From: David Margolis-Pineo
To: Jean Fraser; Philip DiPierro; Tom Errico
Date: 10/23/2015 1:29 PM
Subject: Fwd: 81 Industrial Way
Attachments: 04479CSK-1.pdf

I understand that you are OK with this amendment (first attachment) to substitute the culvert for the bridge.

Per our discussion, I have attached a sketch of the revised grading and utility plan (focused on the walkway leading from the building to Industrial Way). As you will recall, the original plan depicted a wooden foot bridge over the existing roadside drainage ditch. Due to concerns that the railing for the bridge would be damaged or destroyed during street plowing operations, the bridge has been replaced with a culvert and continuation of the paved walkway. After speaking with David Margolis-Pineo, the proposed culvert will be reinforced concrete pipe to be consistent with the Technical Manual. At this time, there are no additional site elements proposed in the vicinity of the walkway. We hope that this modification will be considered a minor change and can be approved by planning staff. Let me know if you require additional information.

SITE PLAN
OF:
LOT 5 INDUSTRIAL WAY
81 INDUSTRIAL WAY
PORTLAND, ME 04103

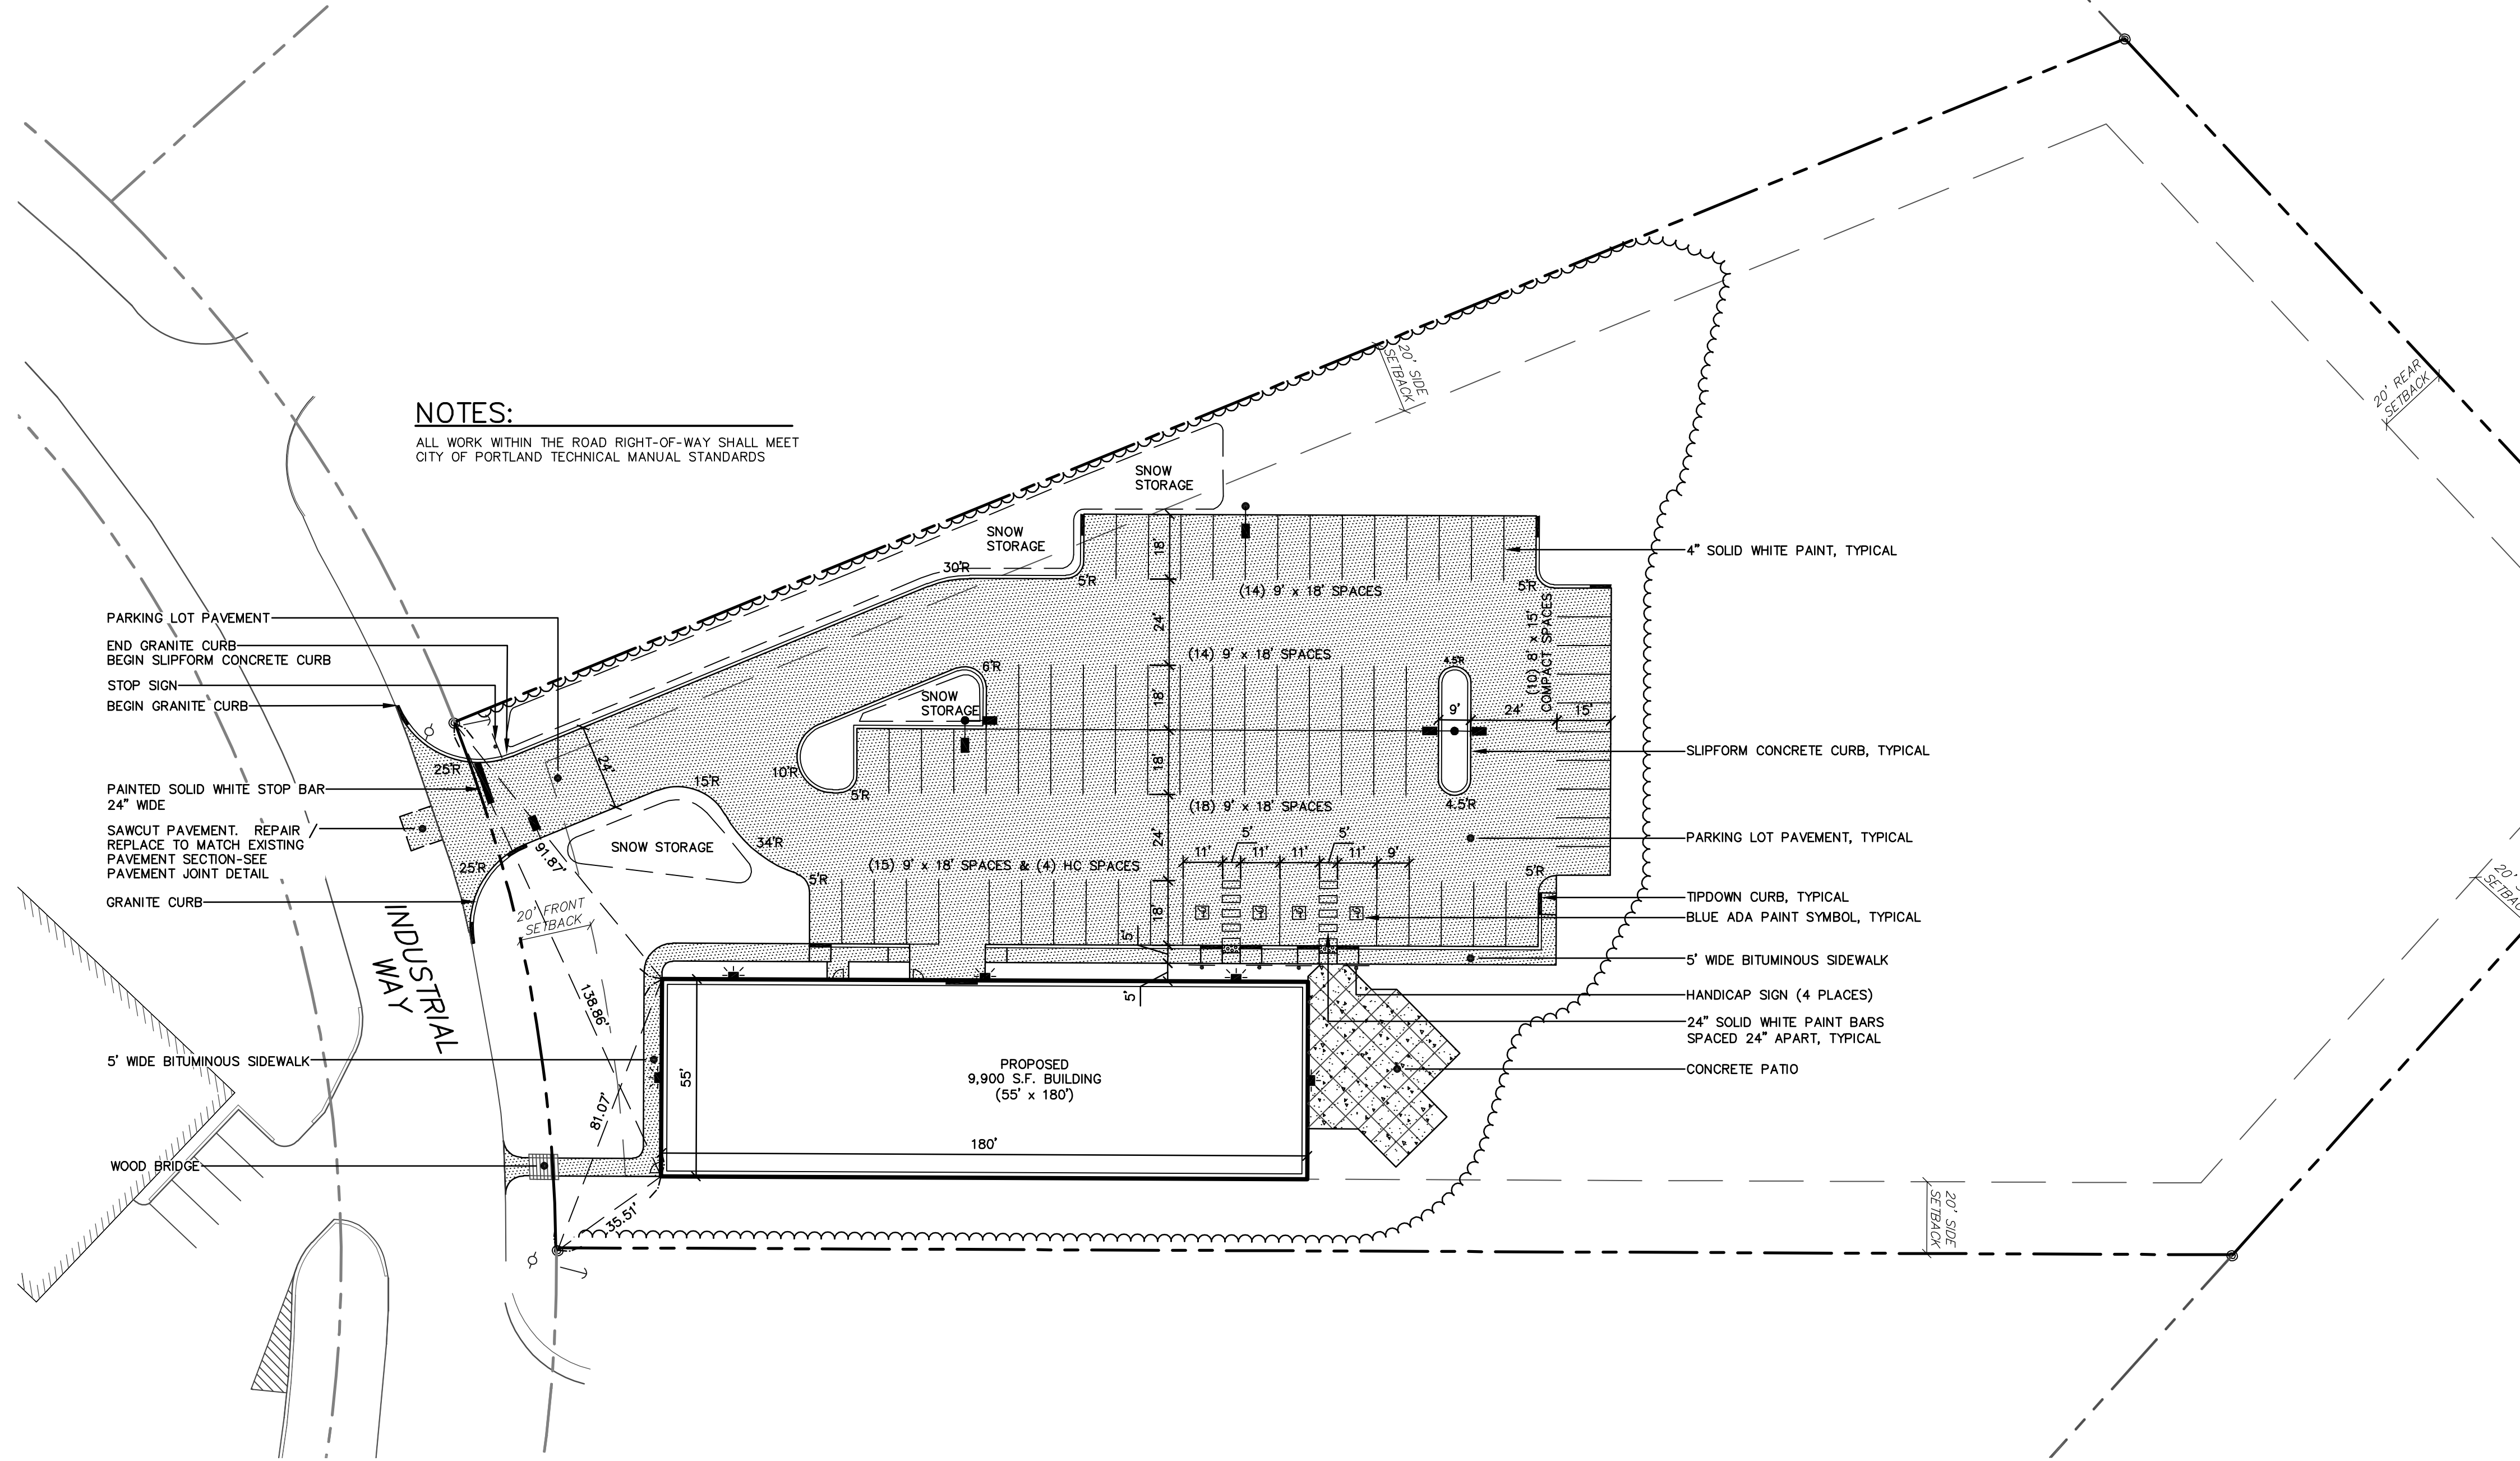
My only very slight concern is that the bridge would have had railings and been more obvious as a destination for people/employees crossing the street, and maybe the access walkway would be more likely to be plowed in the winter. Not sure that this matters.
